From: Sarah Burrow <Sarah.Burrow@arun.gov.uk>
Sent: 27 October 2020 16:57
To: Planning.Responses <Planning.Responses@arun.gov.uk>
Cc: Maria Tomalova <Maria.Tomalova@arun.gov.uk>
Subject: RE: Planning Consultation on: Y/101/20/DOC

Engineers Comments Regarding Surface Water Drainage

Application No: Y/101/20/DOC

Site Address: Yapton Metal Company Burndell Road Yapton BN18 0HP

DESIGN D3 (UNDER VERGES - <900 COVER)
DESIGN D4 (UNDER CARRIAGEWAYS - <1200 COVER)
BEDDING DETAIL - CLASS 'Z'

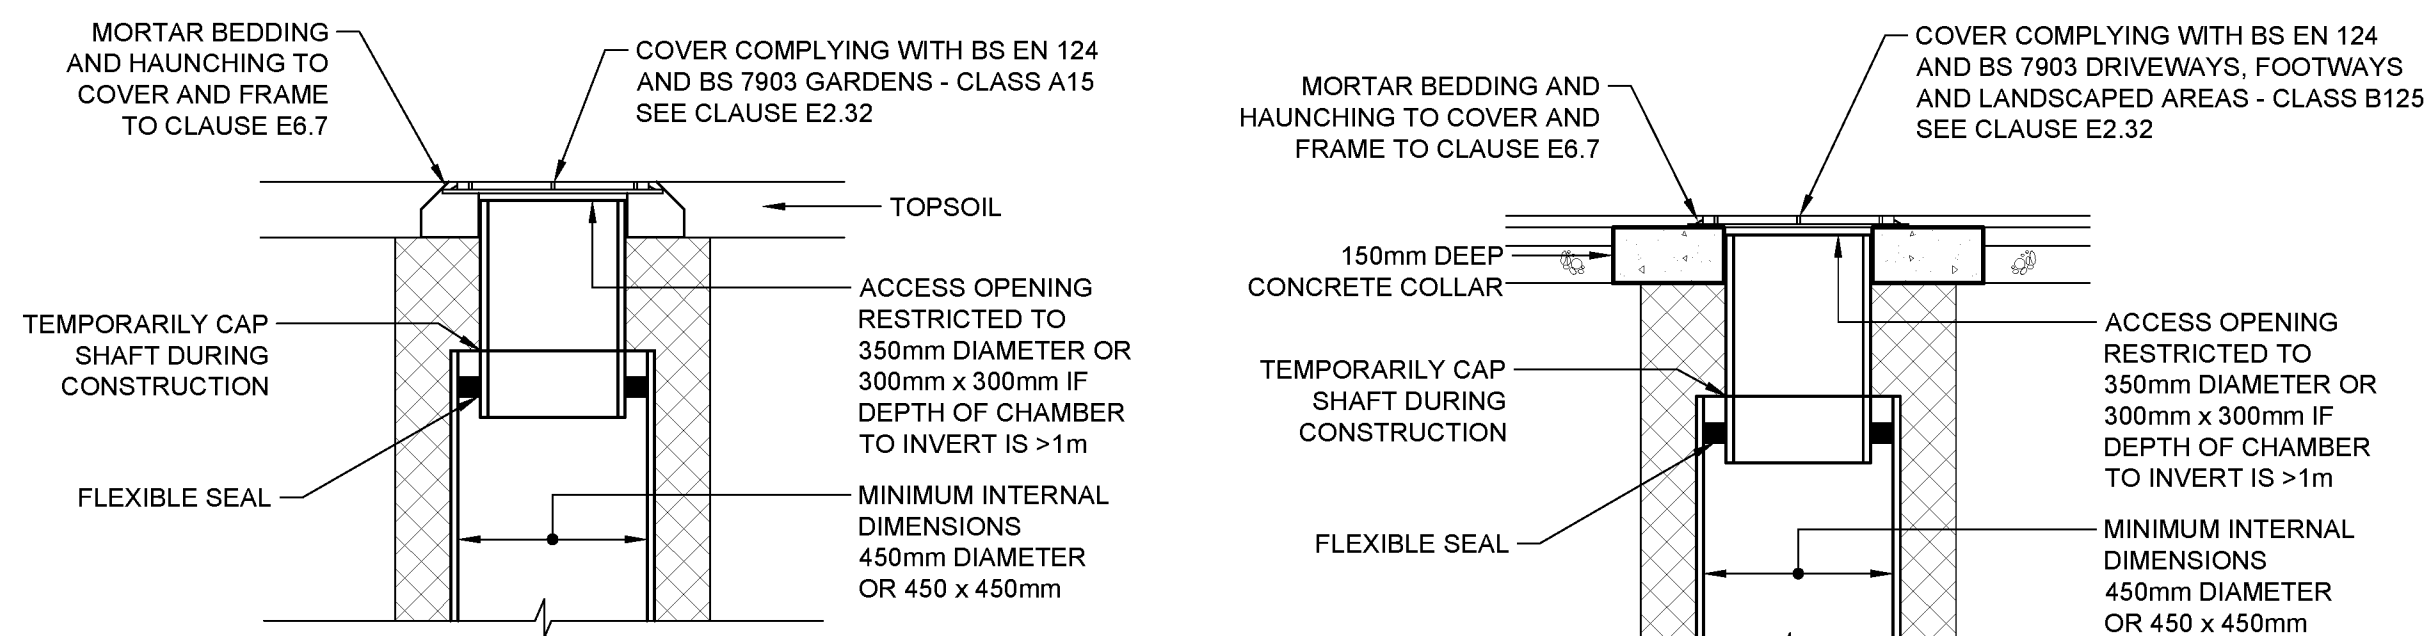
Note, for future applications we would expect to see a Class Z pipe bed and surround (full concrete surround) for pipes laid at this depth under vehicular areas. However, given that all other previous points have been met, and given the prolonged consultation stage it will be overlooked in this instance.
